Subject: RE: Planning Consultation on: Y/17/21/DOC

Engineers Comments Regarding Surface Water Drainage

Application No: Y/17/21/DOC

Site Address: The Steddles North End Road Yapton BN18 0DT

Client	Elberry Homes
Project	The Steadies
Yoplin	
Title	Drainage Details

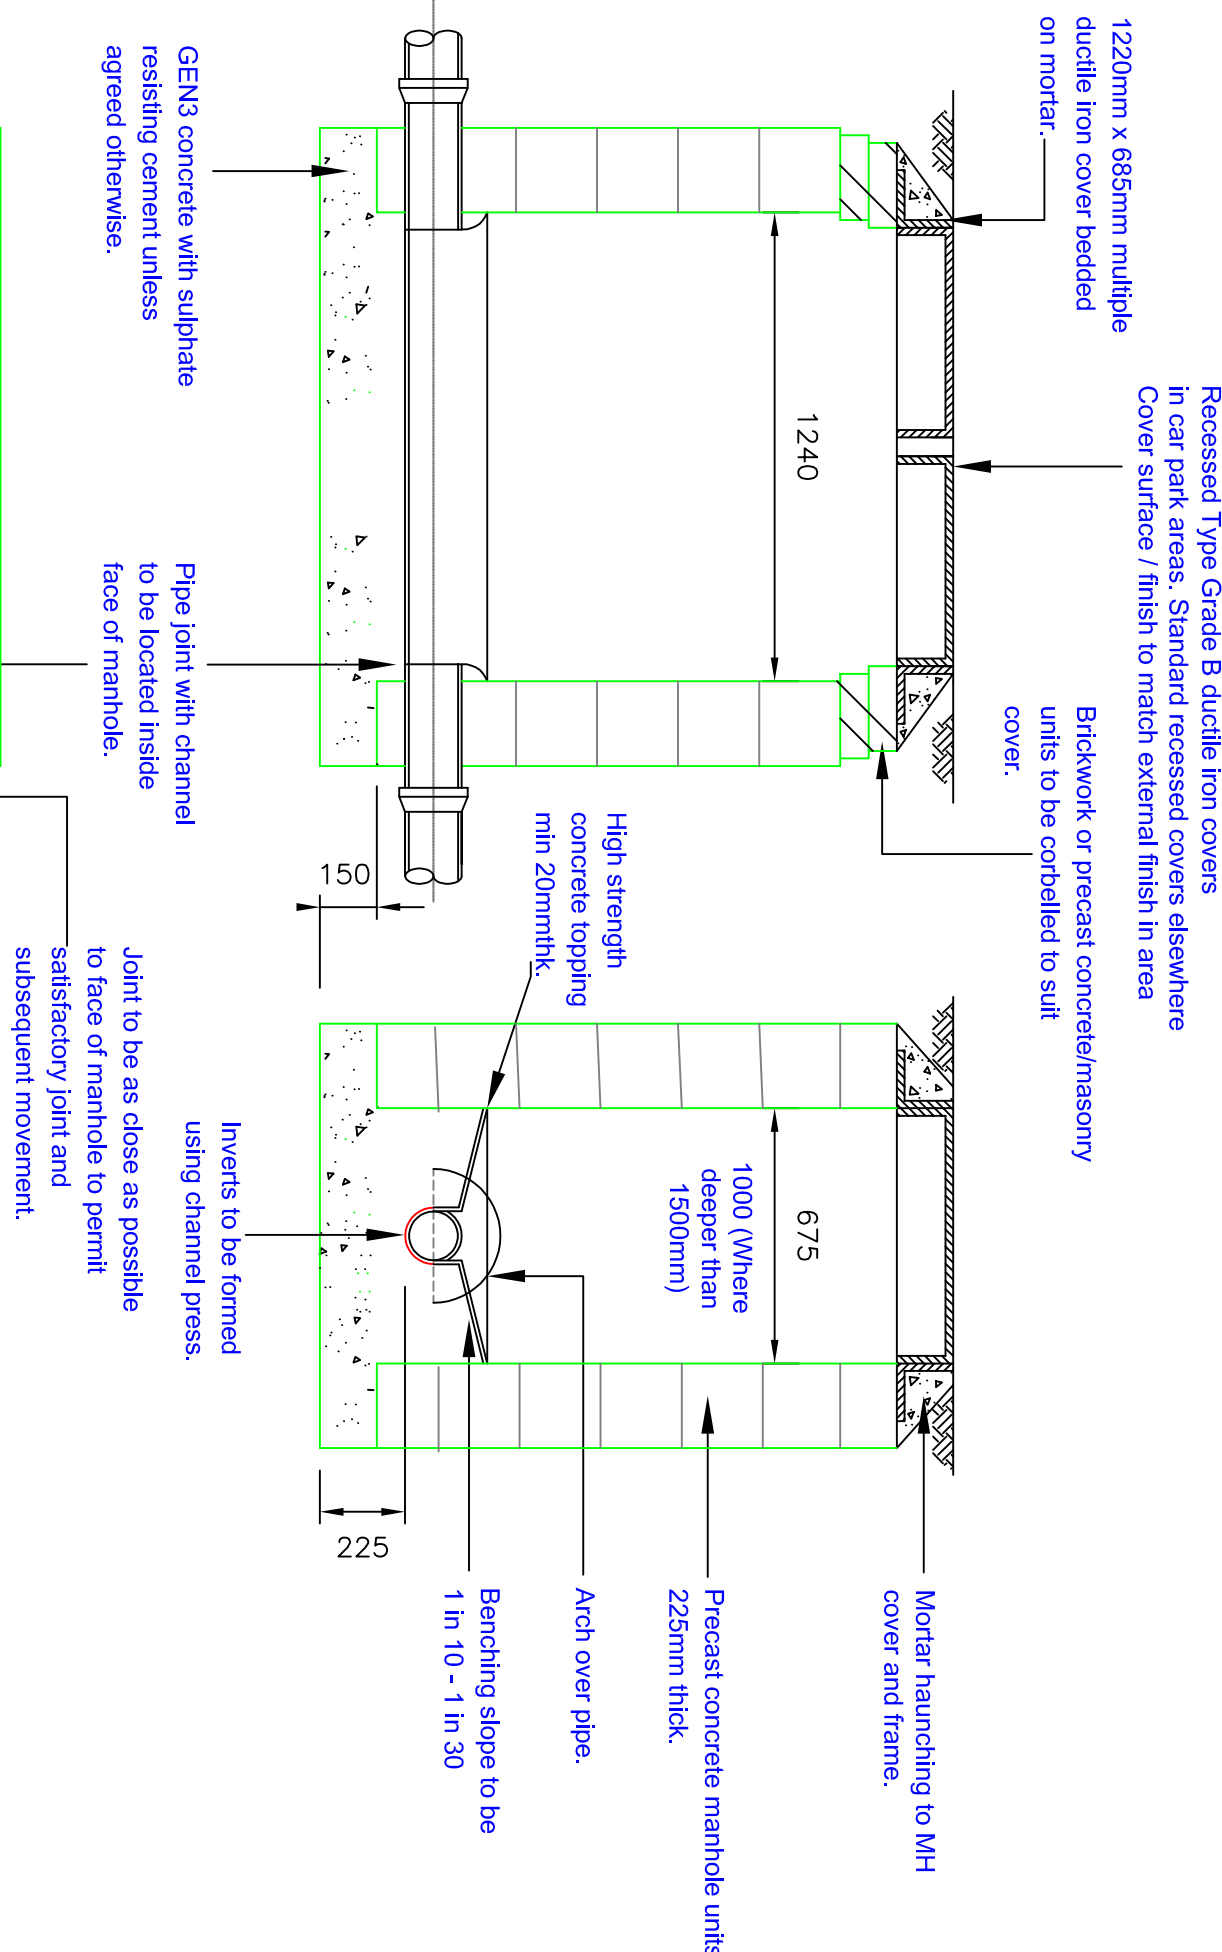
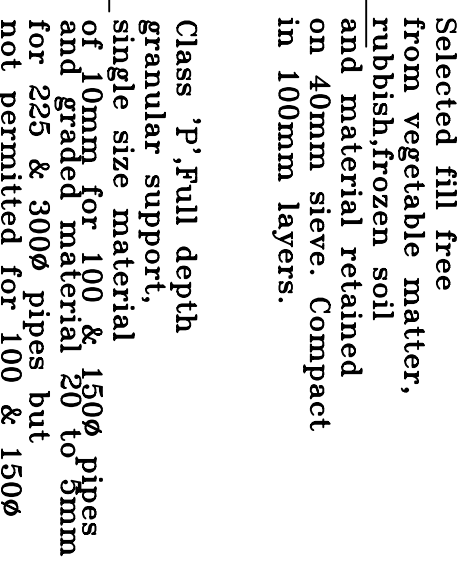
5. Detail A – Section through pervious pavement: This detail shows 400mm Polypipe Permavoid Modular sub-base replacement and infiltration system. As stated in point 3 the calculations state a minimum depth of 500mm below inlet pipe to soakaway invert level. Please correct.
6. Rainwater Downpipe Drainage into Permavoid Raft: Construction detail shows min 300mm sump, Drainage GA Dwg shows 200mm sumps on all inspection chambers before inlets. Please correct.
7. Please ensure that inlet pipes are not showing entering the soakaways at the base, the minimum depth from inlet to soakaway must be clearly shown.
8. Please check that the proposed crates can be stacked, a brief check implied that Polystorm geocellular range is better for deeper installations.

Title
Drainage GA

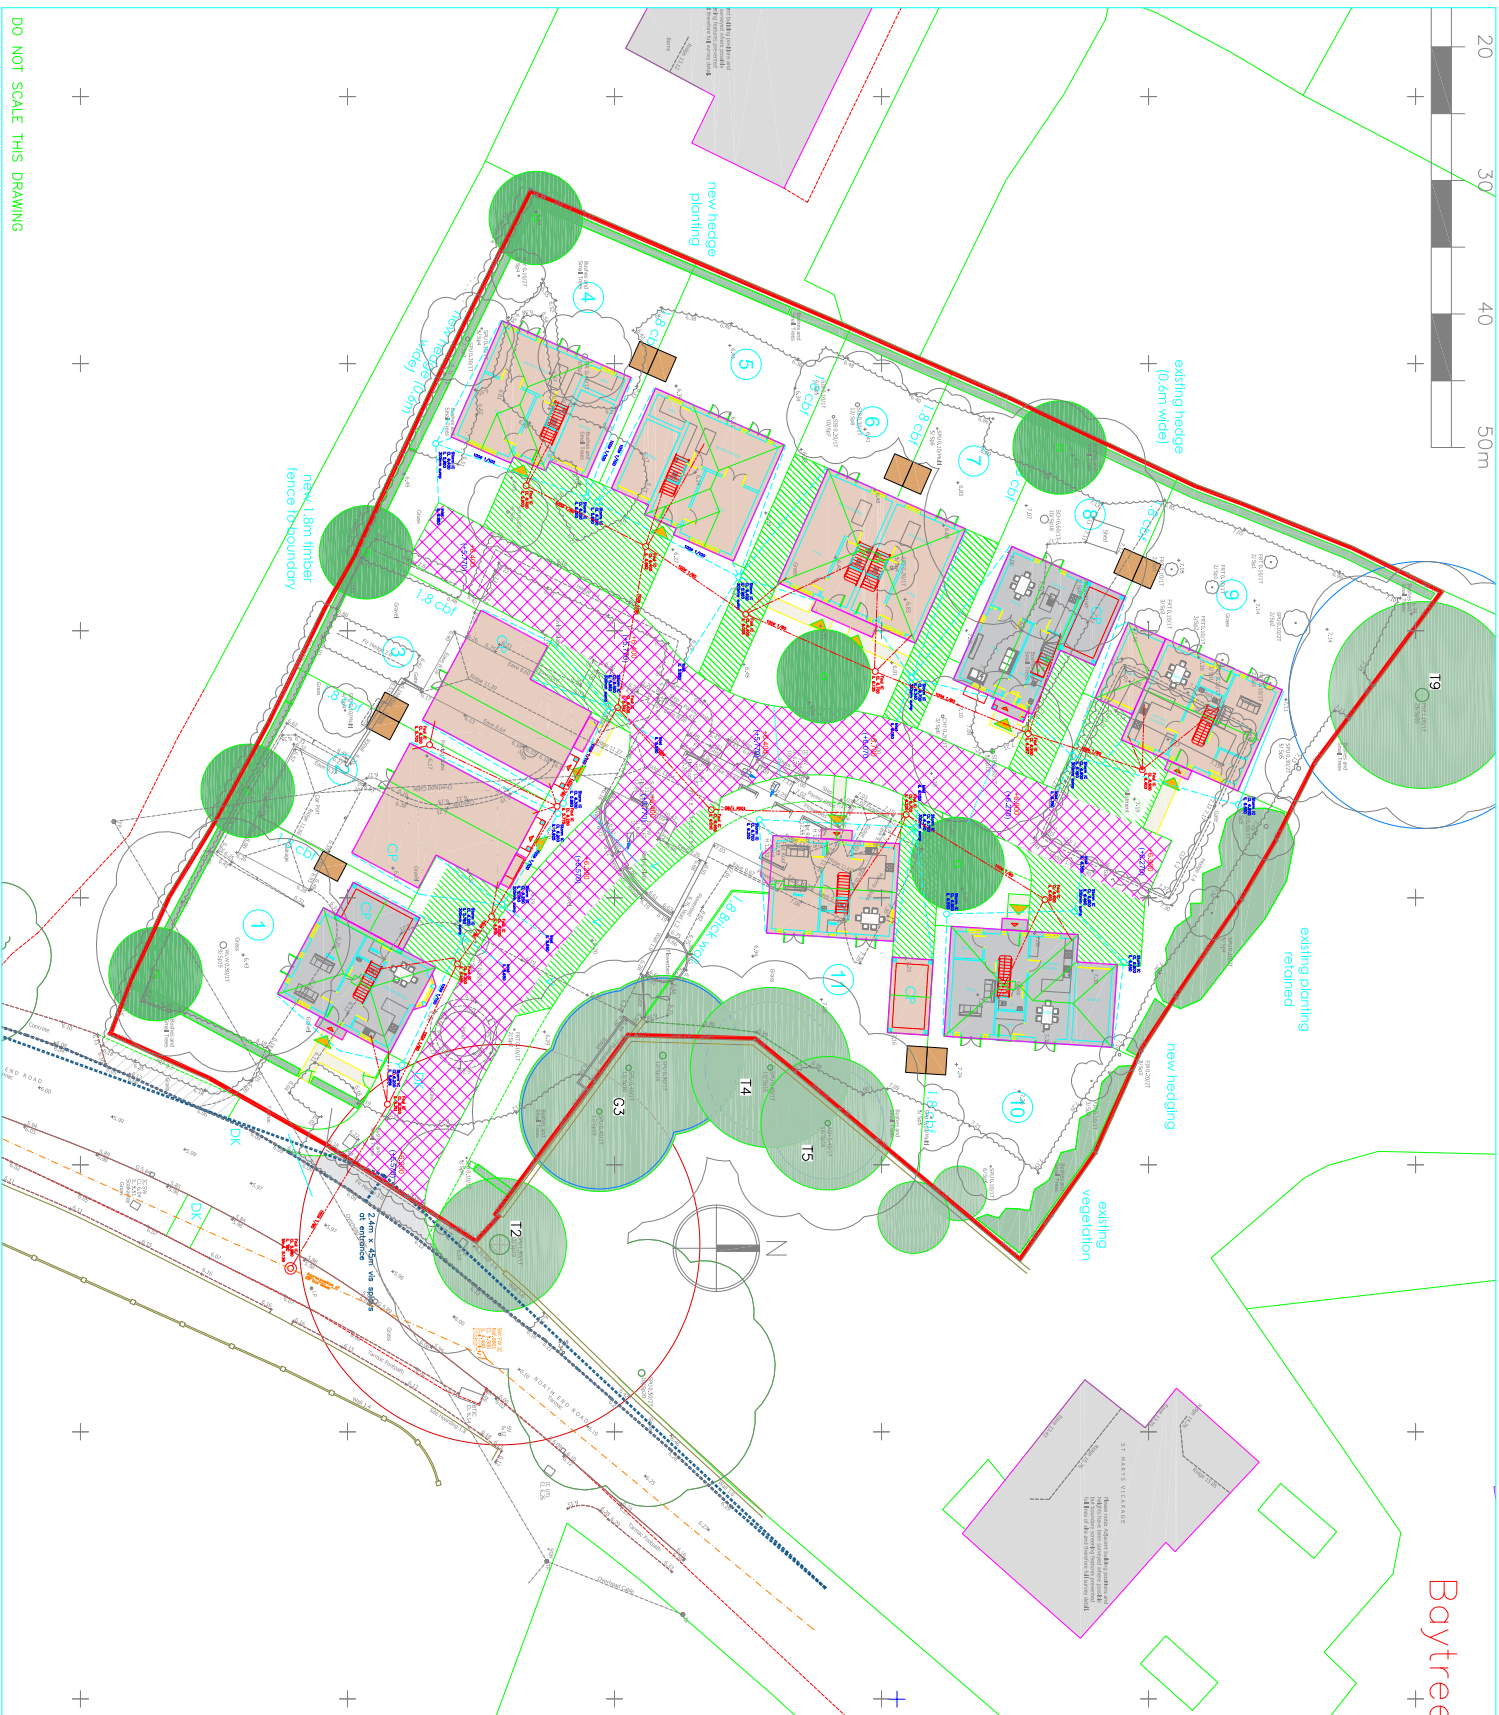
1. Please ensure that all inlet pipes (into the soakaway) are at least 5m from the buildings. It is not clear if this is the case, please check the distance from plots 1, 2 and 3 and the respective inlet pipes.

2. In some areas the soakaway comes within 5m of the buildings (plot 2 and 3, possibly 1). The applicant should check that this will meet the approval of the Building Inspector and evidence this. If the design does not pass Building Regulations a new DOC application would have to be made.

3. Please show the invert levels of inlet pipes. The calculations show a depth of 0.5 below invert depth of inlet pipe, however, given the invert levels of some of the inspection chambers this will not be possible as drawn. A number of inspection chamber invert levels are either 10mm or 30mm above the invert level of the soakaway. The 1 in 10year event +40% must be stored between the base of the soakaway and the inlet pipe invert as a minimum. According to my calculations this is a depth of approximately 80mm. Please ensure that the new invert levels still allow the pipes to achieve self-cleansing velocity.

4. Check that there are no clashes between the proposed foul and the surface water drainage systems (currently there would appear to be clashes at plots 2 and 3 – this may not be the case after the adjustments required from points 2 and 3).
